Great Yarmouth Third River Crossing Order 202[*]

Document NCC/GY3RC/EX/064: Response to Written Submissions made by the Environment Agency at Deadline 5

Author: Norfolk County Council

Date: 11 February 2020

GYTRC-WSP-EGN-XX-DR-EN-2114

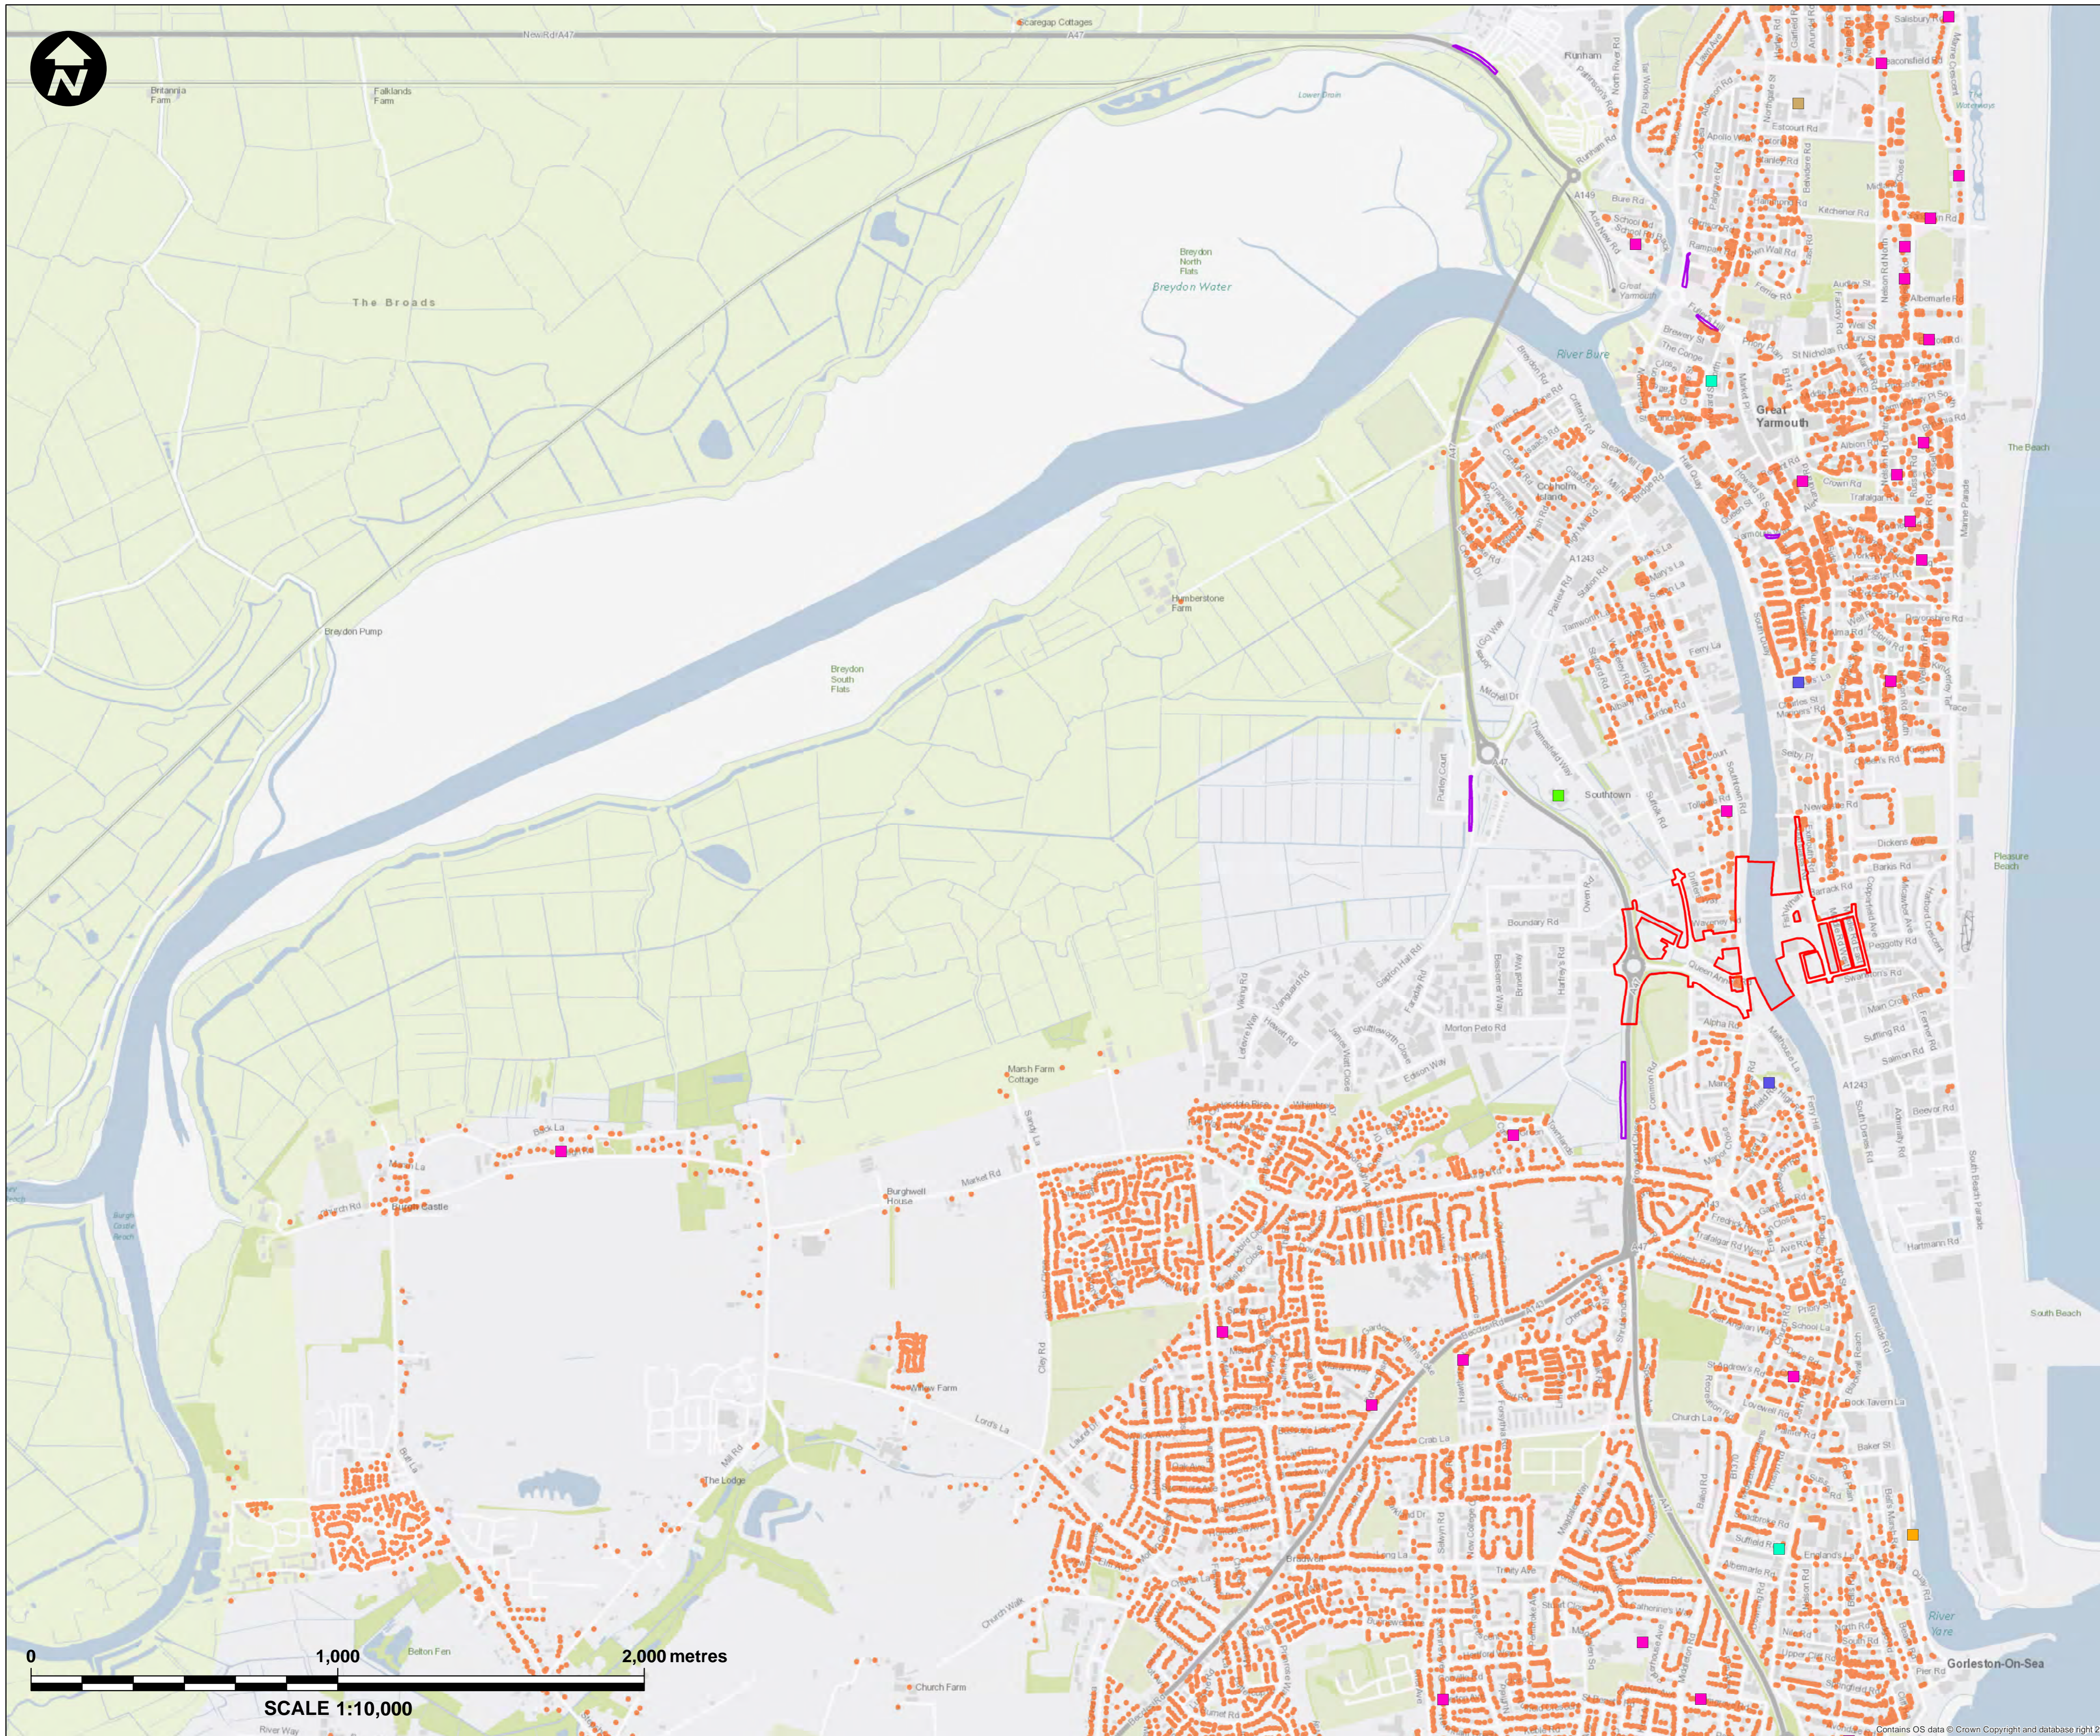
- 2.1.16** Figure 12B.1 of the Appendix shows the flood risk receptors identified within the assessment study area. We have concerns that this figure appears to be missing a substantial amount of receptors that are relevant to the site. It is likely that a significant number of these missing receptors are dwelling properties. This issue was raised with the Applicant in April 2019. If this figure is showing the receptors that have been used in the FRA, then the Applicant will at least need to account for why significant numbers of receptors in areas close to the scheme are not accounted for and it may be necessary to re-assess those receptors.

- 2.1.19** The Applicant acknowledges the erratum in Figure 12B.1 in that it does not contain all receptors as noted by the Environment Agency. The Applicant can

confirm that all receptors contained in the OS Address Base Data were included in the modelling which underpins the FRA (Document Reference 6.2, Planning Inspectorate Reference APP-135).

- 2.1.20 A corrected version of Figure 12B.1 without the erratum is included as Appendix B to this Written Submission.
